**Consultation Response from Mike Hibbert,
KC Waste Strategy(Refuse & Recycling)**

2023/91116 Land off, Primrose Lane, Hightown, Liversedge, WF15

Erection of 67 dwellings

Responding Ref: WPN 23 -022

PRIMROSE LANE REFUSE PLAN			
title: PRIMROSE LANE HIGHTOWN		client: JONES HOMES	
client ref:		Niemen Architects Deck 2, The Waterscope Firwood, Leeds LS5 3EG T: 0113 239 5400 office@niemen.co.uk	
date: 09/11/22	scale: 1:500@A1	drawn: PG	checked: ED
drawing no: 3416-1-110	revision: J

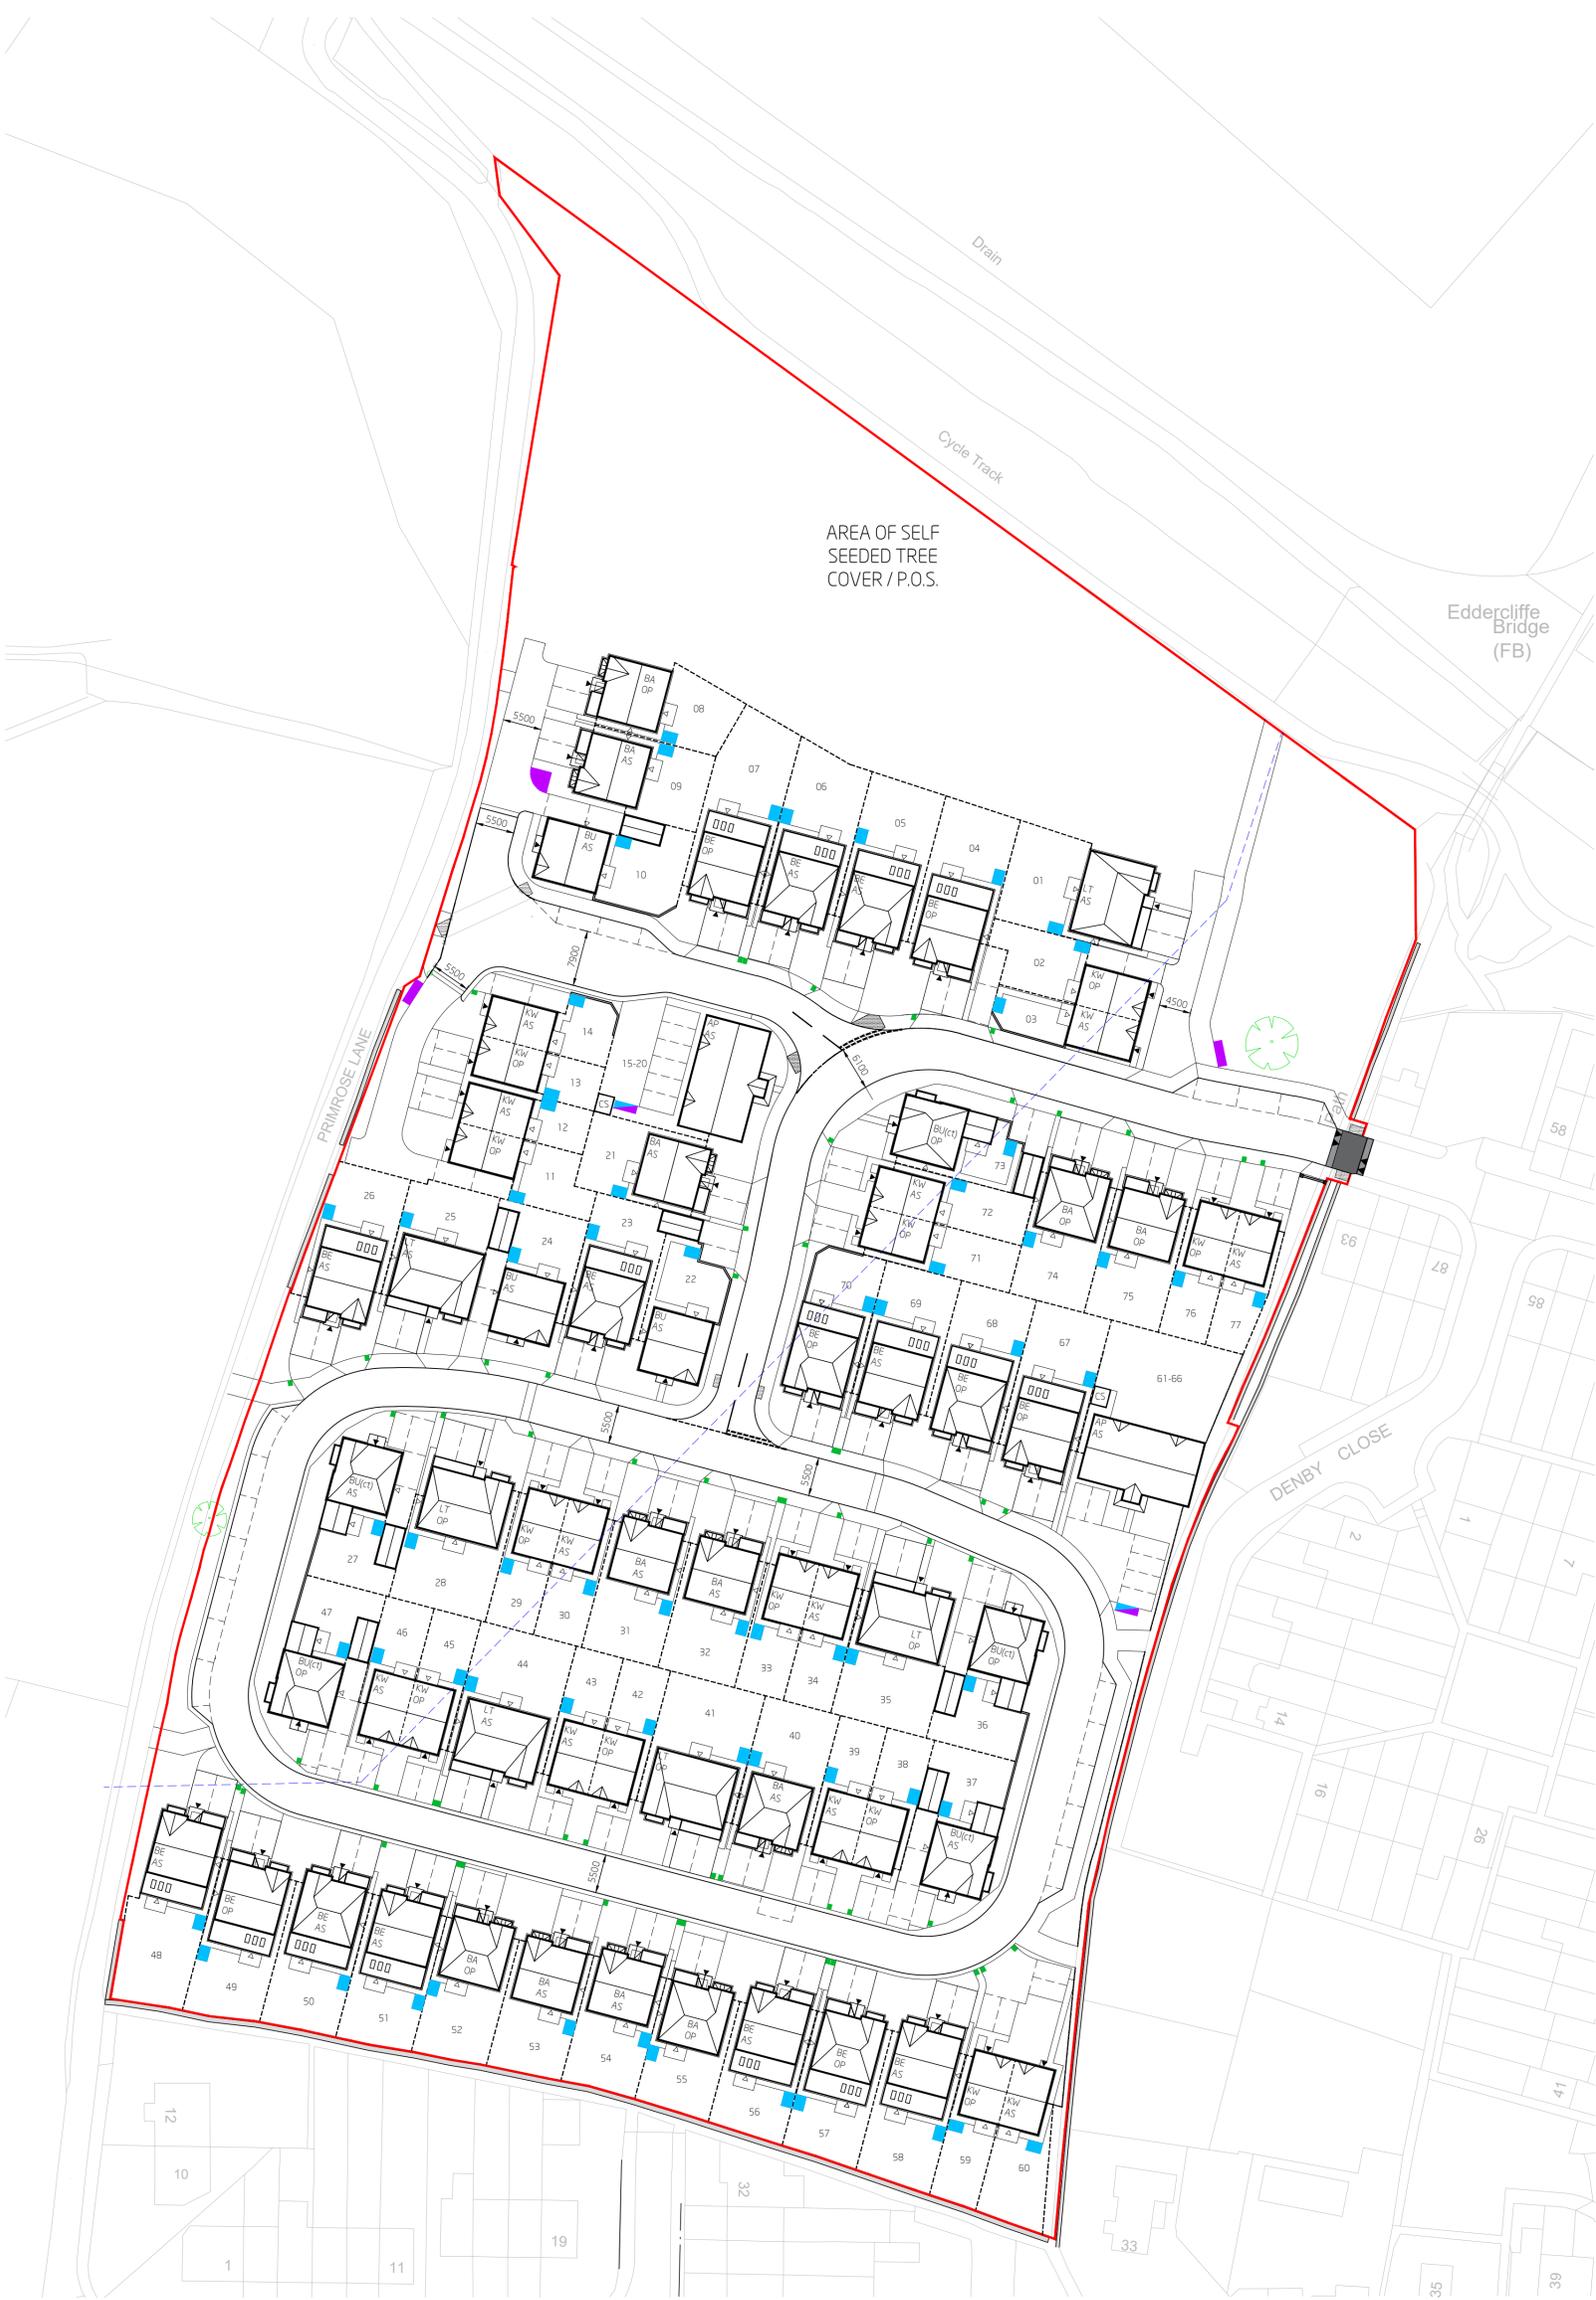
The applicant has submitted Refuse Plan - 3416-1-110 Rev F dated 31/3/2023 that is annotated to show the location of Bin Collection Points (BCP) in purple, combined BCP's/ Bin stores in purple/ blue, individual bin stores at properties in blue and bin presentation points in green. It is welcomed that the scheme includes a loop road enabling access to most of the proposed properties on the development.

- The plan shows provision on each individual plot (apart from apartment blocks) of bin storage at the rear of properties. The storage area footprint is approximately 2.2m x 1.6m that is large enough to accommodate for 3x240 ltrs wheeliebins.

- Access gates from rear gardens must be wide enough for bins to pass through (shown as approximately 900mm on the plan that is acceptable) and space available to navigate around parked cars in driveways.

- On collection day the residents would need to transfer bins to a presentation point close to the adopted highway and not left on the footway. The location of bin stores and presentation points are shown on the plan, and these arrangements are in compliance with guidance.

- Plot 1 is located off the adopted highway. But a BCP is shown within 25m on the access driveway for plots 1 and 2.
- The drag distance from Plot 9 to the BCP is approximately 35m that is in excess of the distance specified in guidance (max 25m). The drag distance from the Bin store to the BCP on the adopted highway is approximately 19m that is in excess 8m (for 240ltr bins). **Reversing RCV's is a recognised safety hazard and WISH guidance**

specifies a maximum reverse distance of 12m. Without provision of a turning head the reverse distance from the loop road to Plot 7 is approximately 35m that is not acceptable.

- Plots 10-15 and 16-21 consist of 6 apartments in three storey buildings. Bin storage areas are shown adjacent to the parking areas for block 10-15 and at the rear (but with access to the highway) for block 16-21. Bin stores currently are shown as 2.5m and 4m from buildings. No details are provided about the construction specification or screening of the bin stores.

- Waste arisings from 6 apartments will be approximately 1080ltrs. This could be serviced either by each apartment having 2 wheeliebins (1x residual and 1x recycle), so 12 bins in total, or provisional of a communal store consisting of 2x1100ltrs wheeliebins with preferably spare for a third bin to accommodate garden waste or glass.

- Access from the bin store to the highway/ RCV collection point should be less than 10m and have a smooth surface with a gradient no more than 1:12. A drop kerb should be installed if there is a change of levels from the access path to the highway. The location of the bin store for block 10-15 may mean access is impeded by parked cars between the store and highway. Consideration should be given to relocating the bin stores closer to the highway. If individual bins are provided householders would need to present bins at a BCP on collection day.

- Storage should address the fire risk issues presented by large quantities of waste. For communal stores they should be located either 6m away from the building or be constructed of suitable material to contain and prevent the spread of fire. See BS5906:2005, Building Regs 2010 Part H6 and CFPA-E Guideline No 7:2022 F.
